**KIRKLEES METROPOLITAN COUNCIL
INVESTMENT & REGENERATION SERVICE**

DELEGATED DECISION TO DETERMINE PLANNING APPLICATIONS

Reference No: 2018/60/92832/E

Description: Outline application for erection of detached dwelling

Location Plan showing Ownership Boundary
1:1250

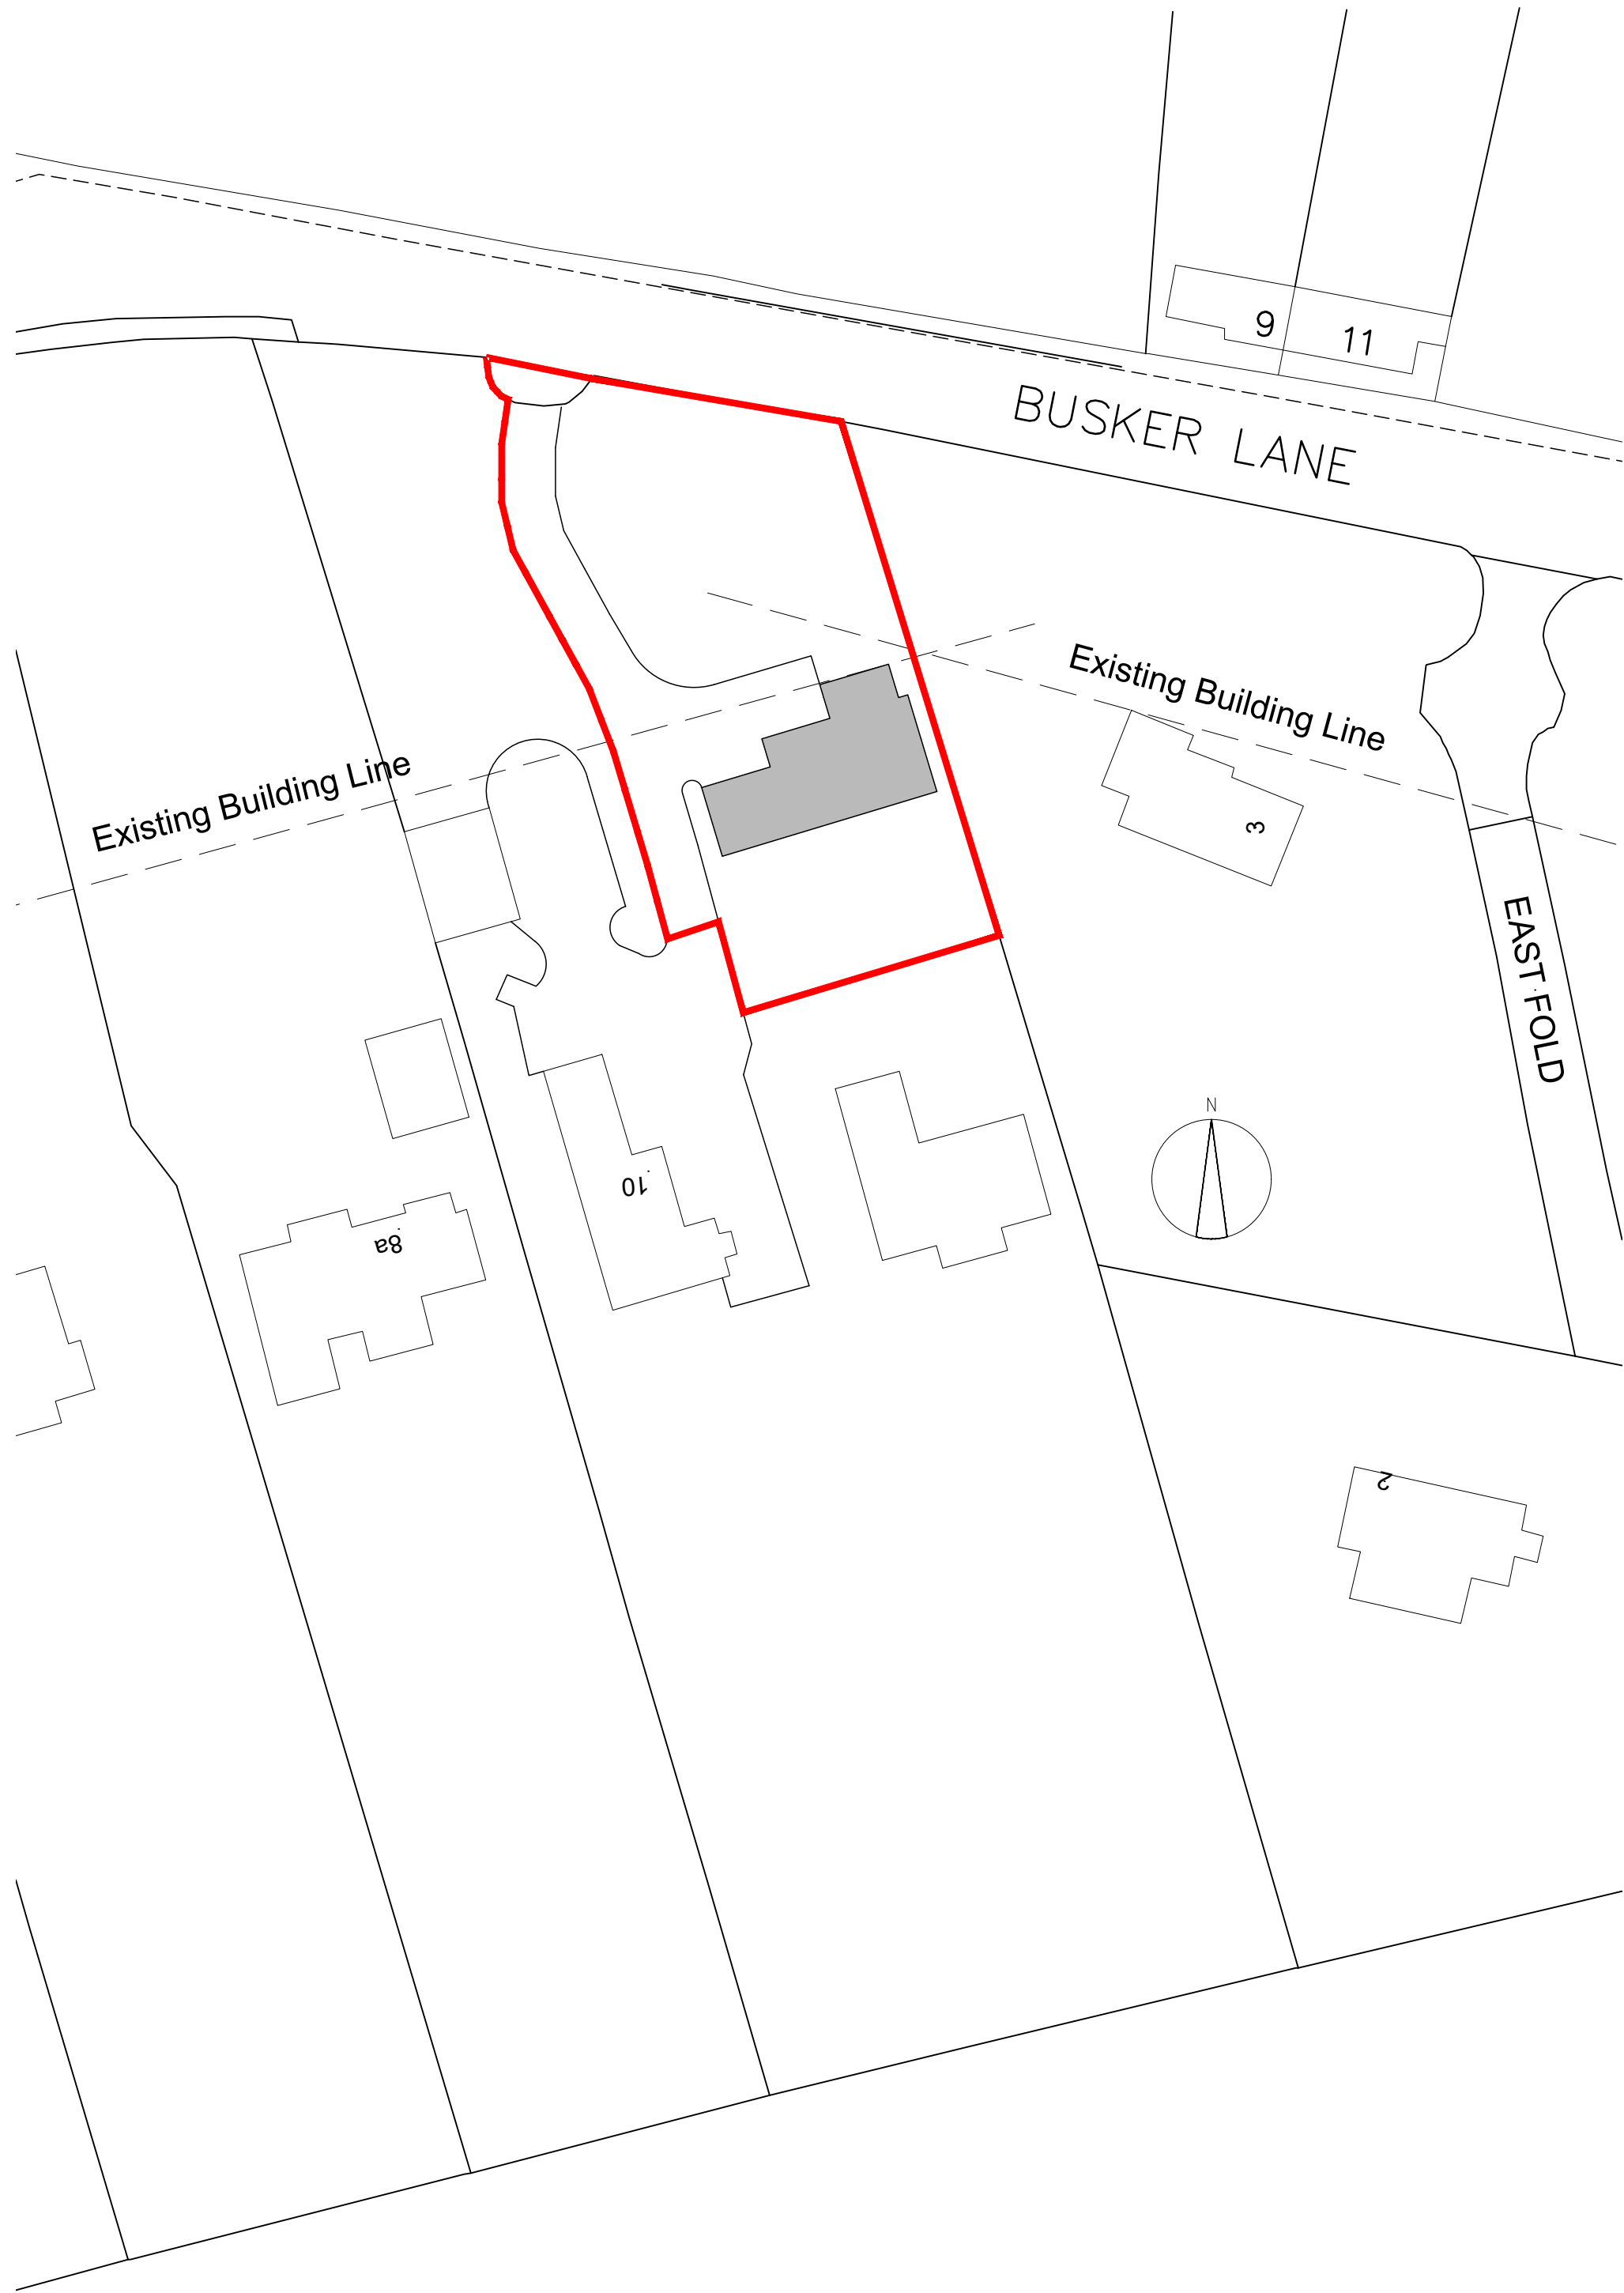
The application site comprises the front garden of Woodley, a large detached property set well back from the road frontage. The site is 0.13ha in size which at a standard density of 35 dwellings per ha could accommodate between 4 and 5 houses. The site is therefore too large to be considered as an infill plot. Nor is it considered that the site is within existing built form as specified by LP59. The application site is the front garden of the house, and while no's. 1 and 3 East Fold are more forward towards the road frontage than Woodley, the new house would extend that pattern, not be within it. Nor can the road frontage be described as built up, as the existing houses are set a very long way back with gardens fronting the road. The site has open fields to the front and a large garden to the west so cannot be said to be largely surrounded by development.

It is possible that a dwelling could be designed so as to be in character with surrounding development however, the introduction of a new building where shown would result in an incongruous feature into this open green belt setting thereby harming the character and openness.

At this outline stage, Highways DM would wish to see improvements to the access to allow vehicles to pass each other where it serves more than one dwelling; a minimum width of 4.5m would be required.

Currently, the sight-lines from the access are substandard, and, given the proposed intensification of use of this site, KC Highways DM would advise that these are improved to the guideline splays set out in Manual for Streets, namely 2.4m x 43m. It is likely this could be achieved by lowering the existing walls and planting nothing taller than 1.0m within 2m of the carriageway edge, then being retained in perpetuity by condition.

It is apparent that there is ample opportunity for adequate off-street parking to be created, but any full application should include parking and turning provision in line with current standards. In this instance the application fails to show adequate visibility and widening and as such is contrary to Local Plan Policy LP21 and LP22.
